**CITY OF MERCER ISLAND**

August 29, 2017

RE: ADU17-003, CAO17-005, SHL17-007, SUB17-004 Second Review Letter  
Land Use Applications for proposed home, ADU, driveway and retaining wall construction within  
a steep slope along the shoreline for the Lady Bug Trust. DEV17-009 Impervious Surface  
Deviation Application has been withdrawn.

Project: 503.01
 Sheet: A2.4
retaining wall plan and details
WORK IN PROGRESS
NOT FOR CONSTRUCTION

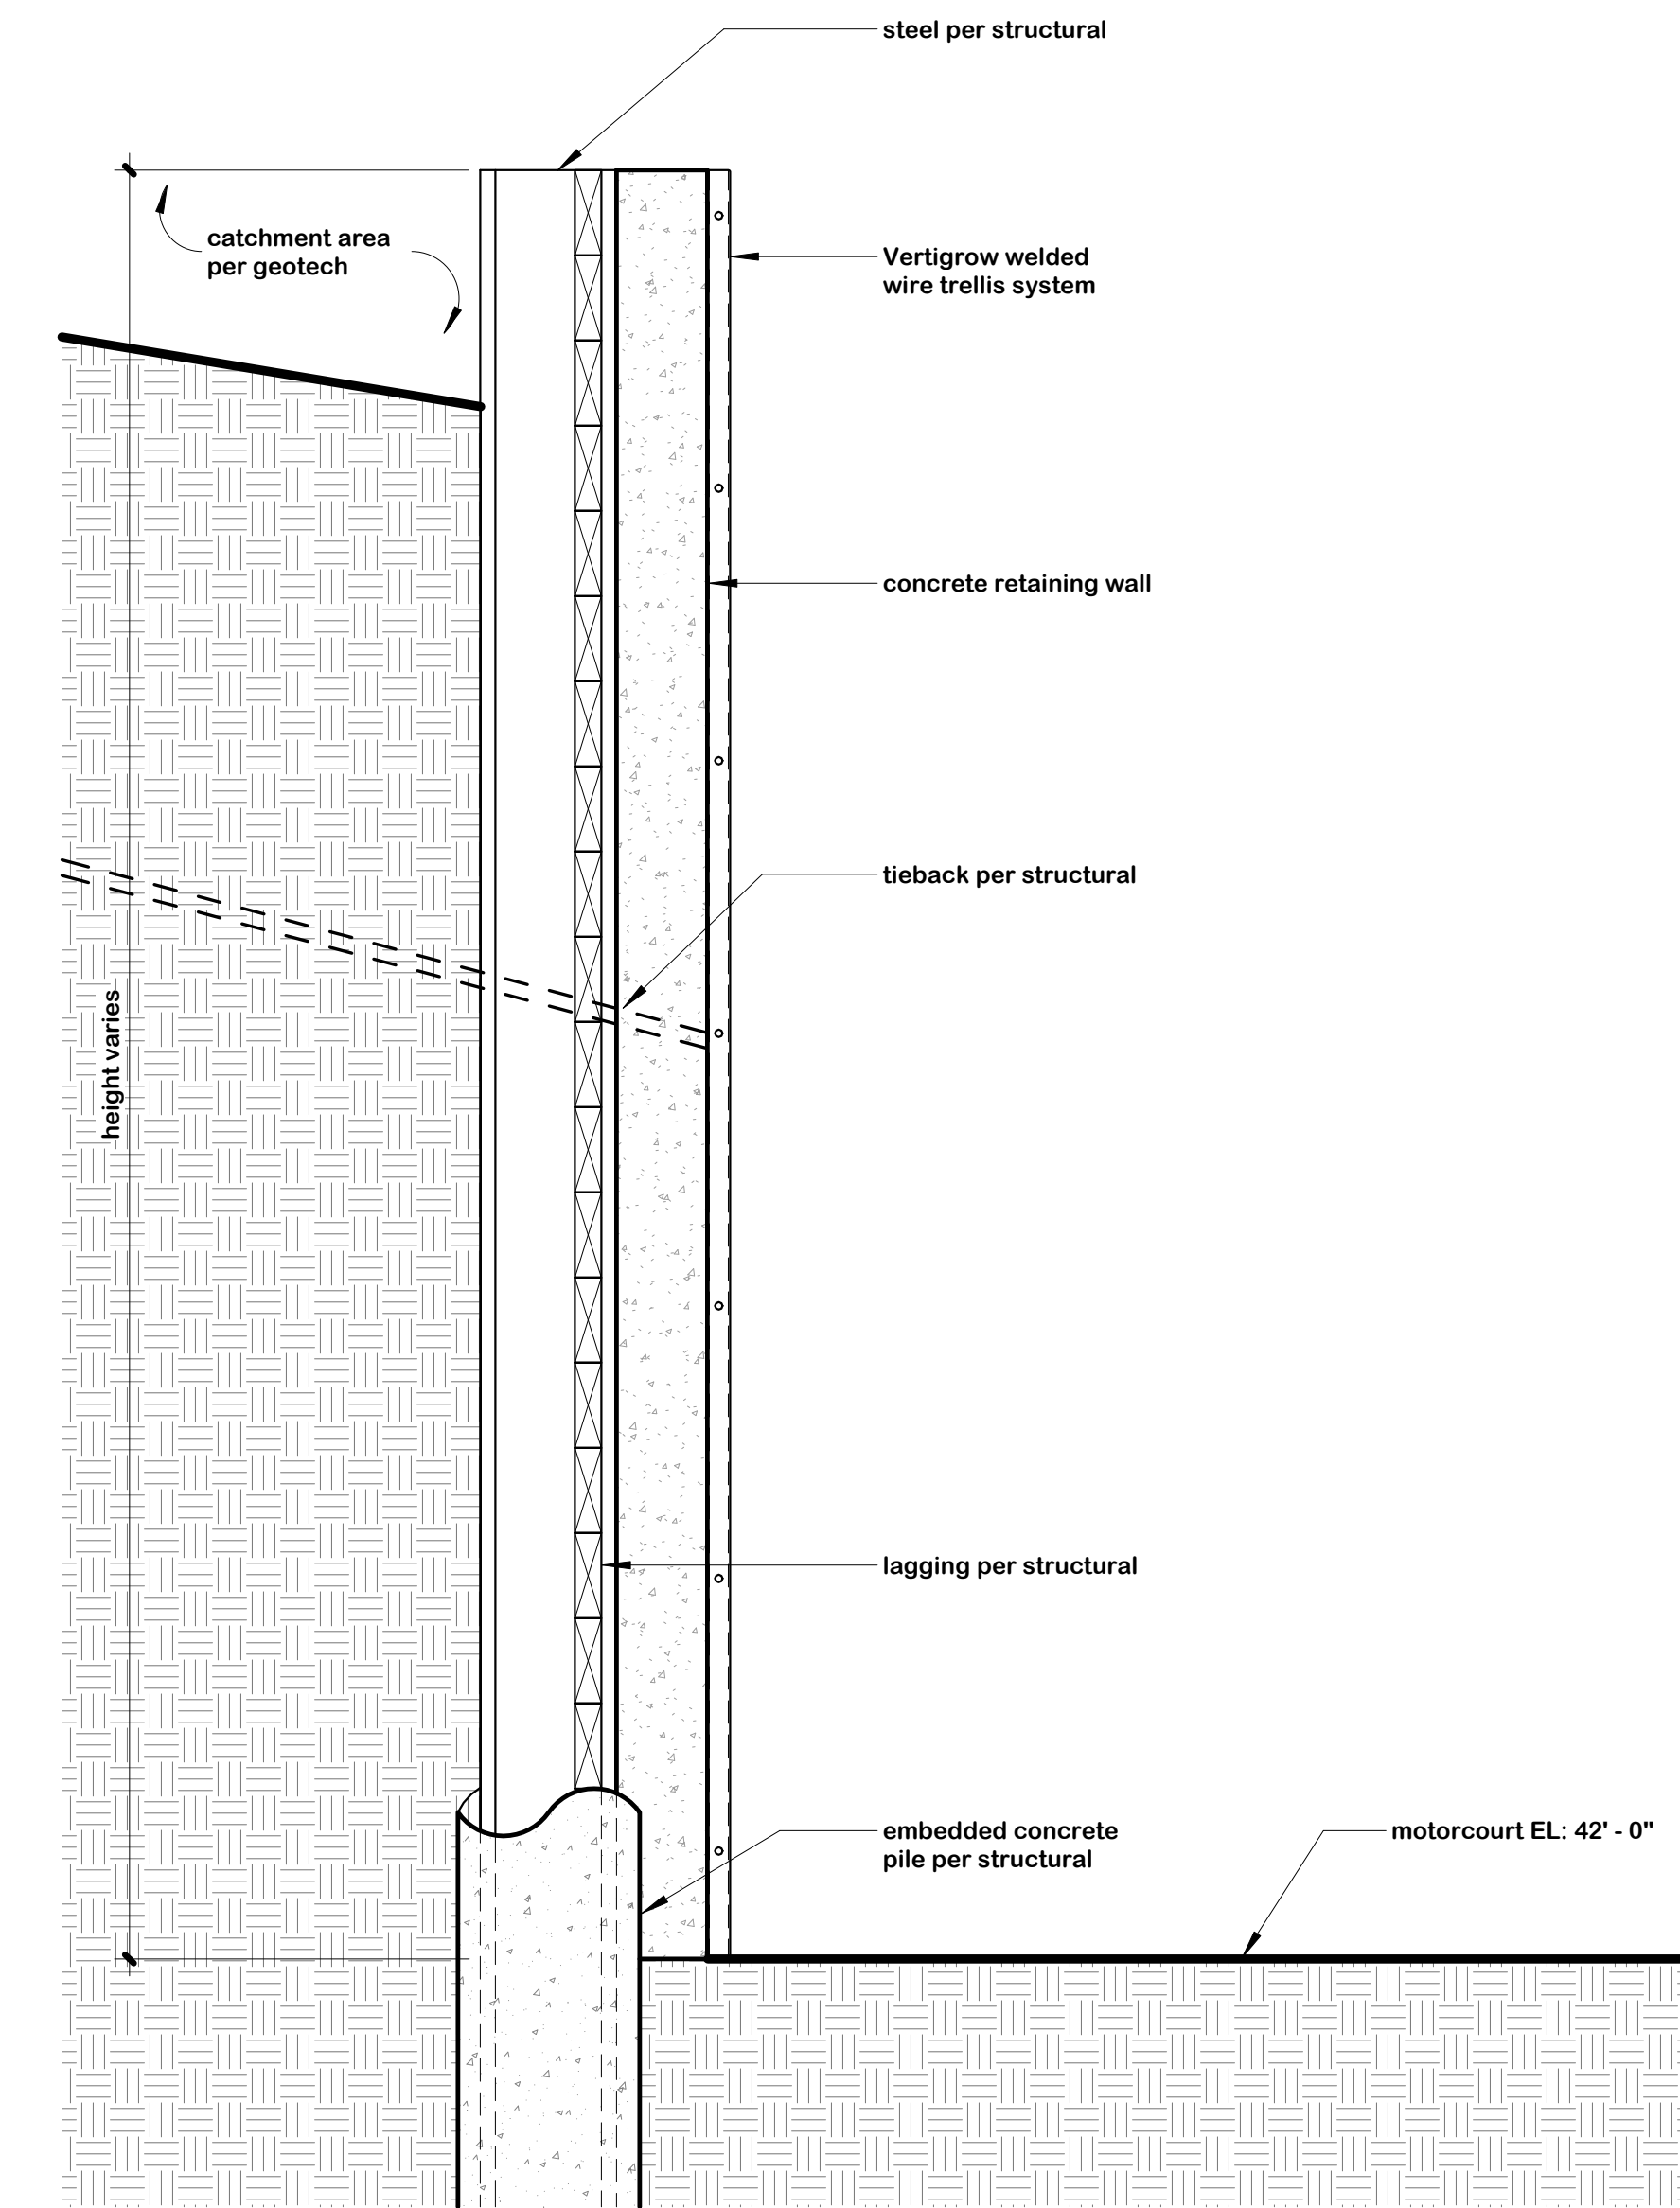
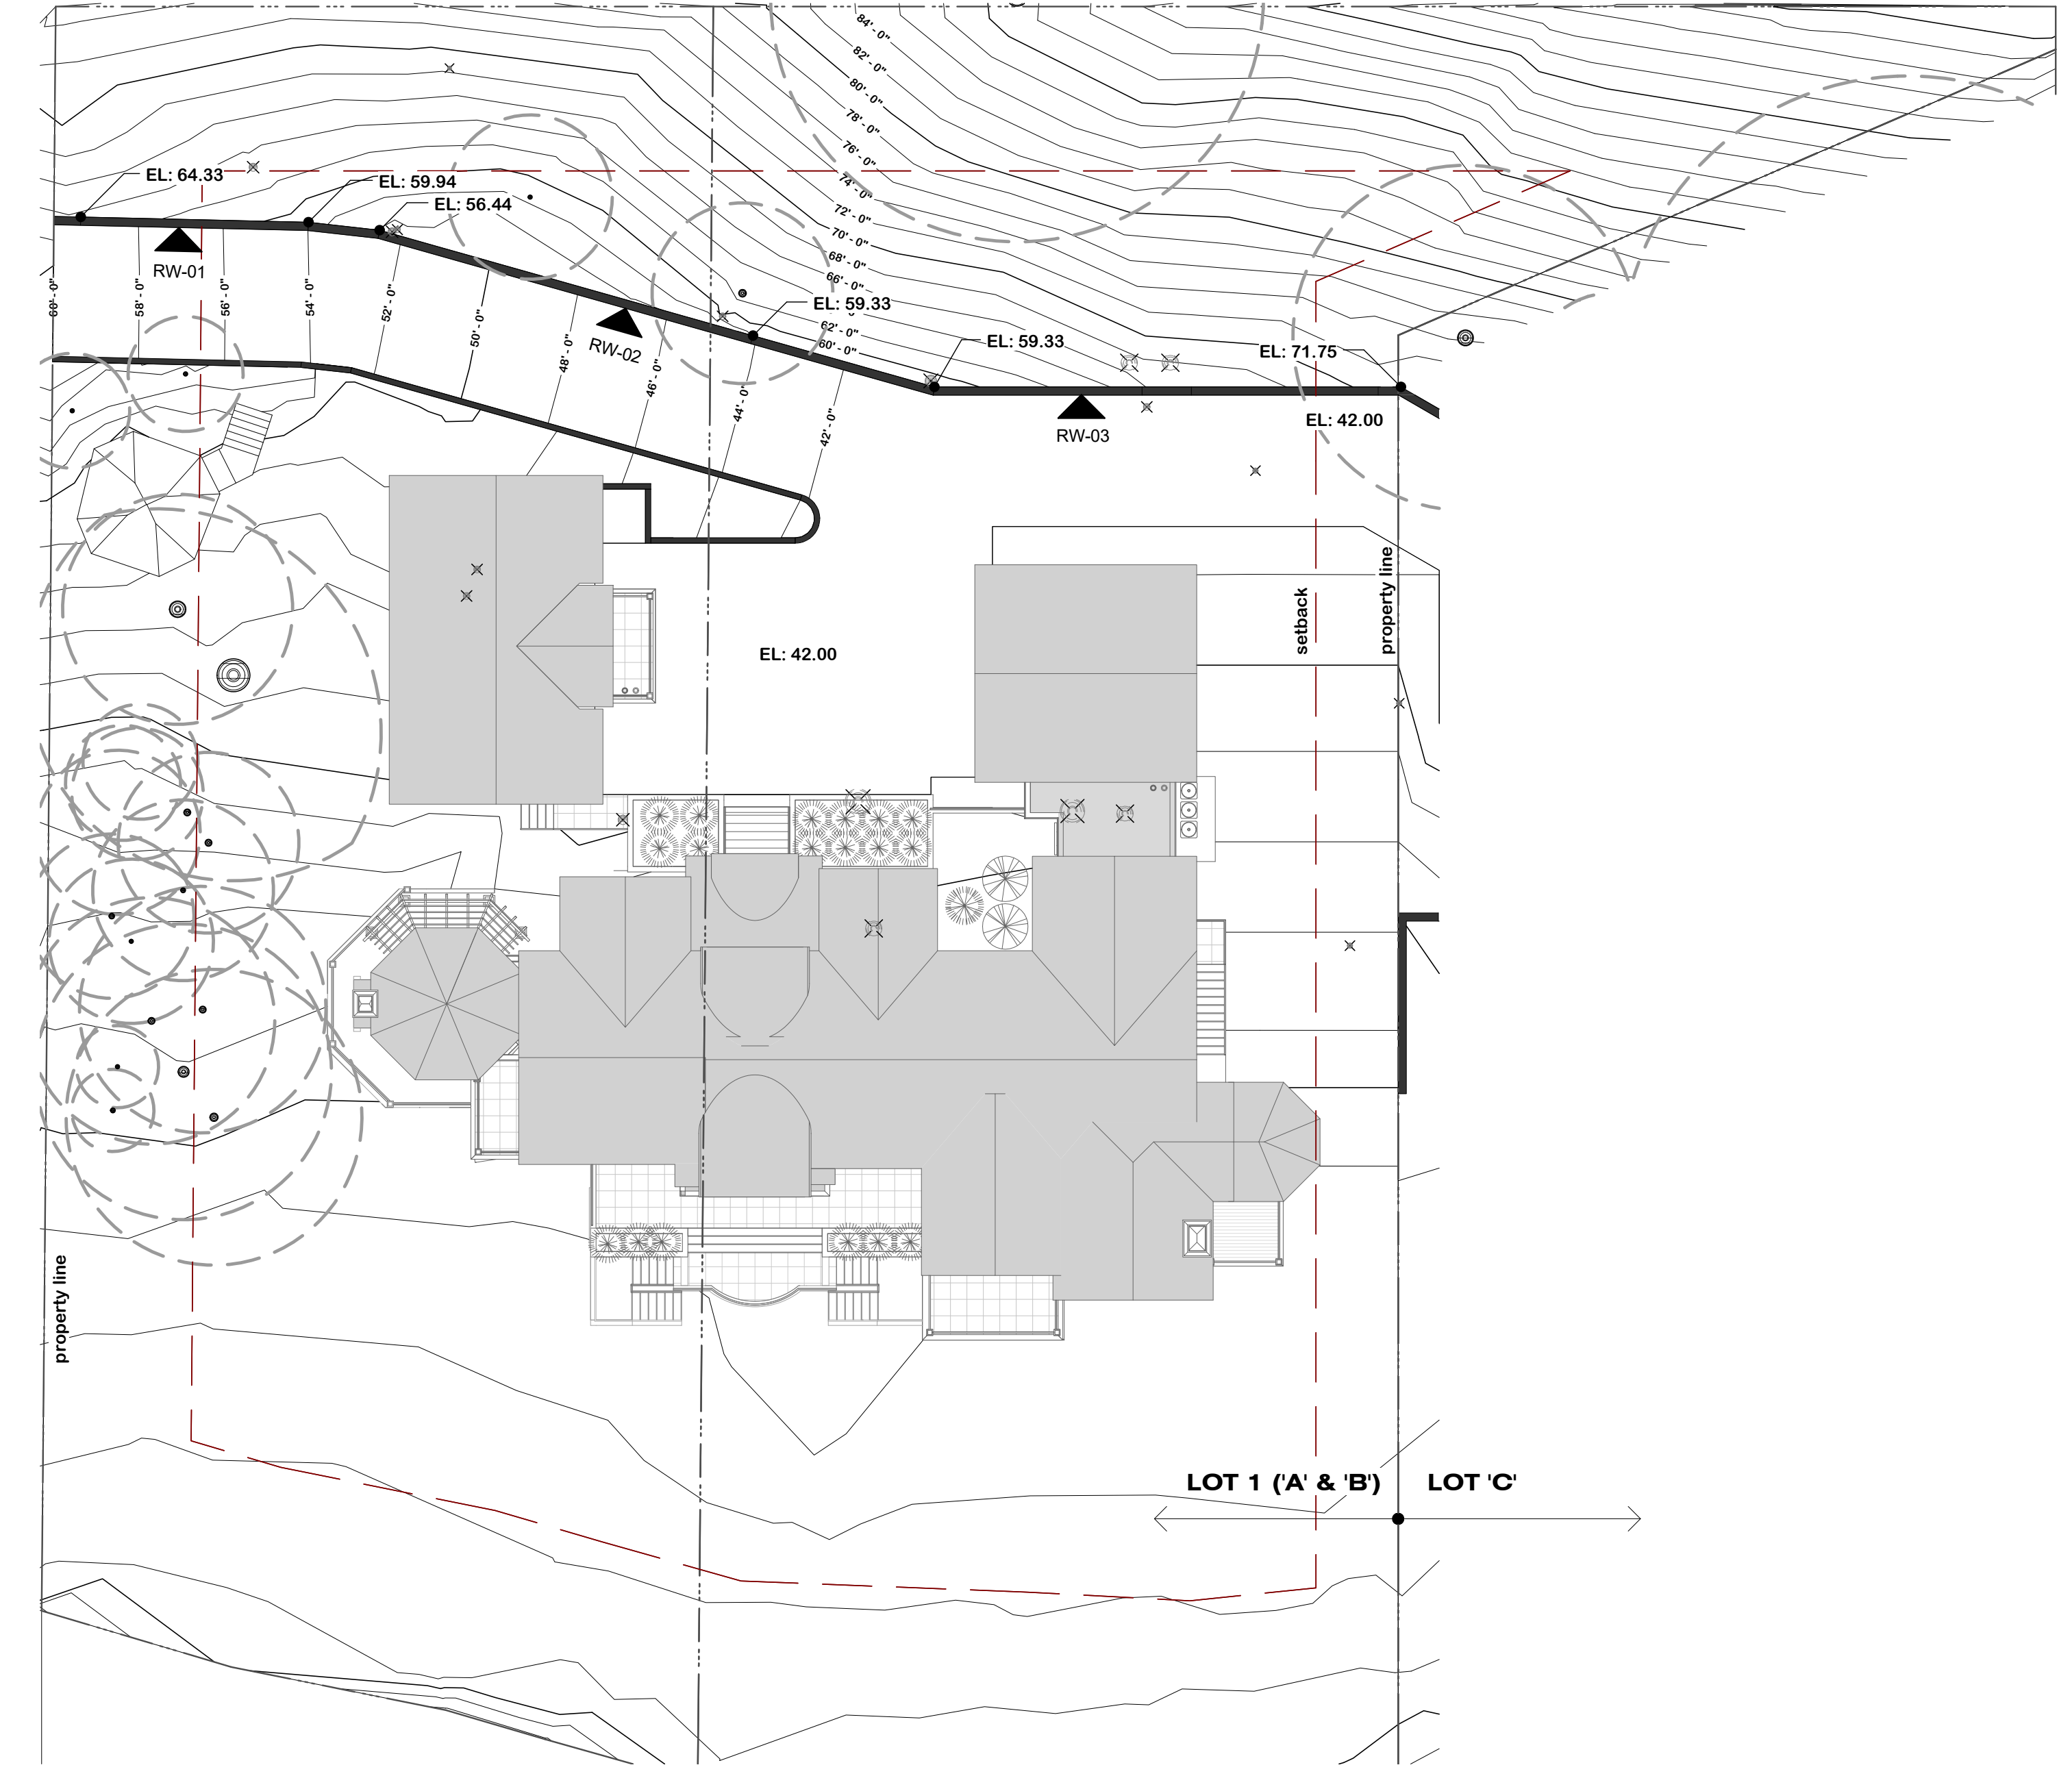
5. Please provide a Construction Management Plan (CMP), refer to the CMP Checklist provided.
6. Please label the setbacks and width on all pages on the plans.
7. On Sheet A2.4, please verify that the proposed retaining walls within the required side setbacks meet our height requirements set forth in MICC 19.02.050. The maximum height is 144 inches for cut slopes, and the proposed retaining wall 03 is in question at a maximum height of

- approximately 29 feet 9 inches. In addition, with the proposed code update, the maximum height of the retaining wall outside of the required setbacks is 17 feet. Please consult with your Geotechnical Engineer and Don Cole (Building Official) about the design of the retaining wall, possible options include stepping the retaining walls and/or raising the driveway from the current proposal (still must meet maximum driveway grade of 20%).
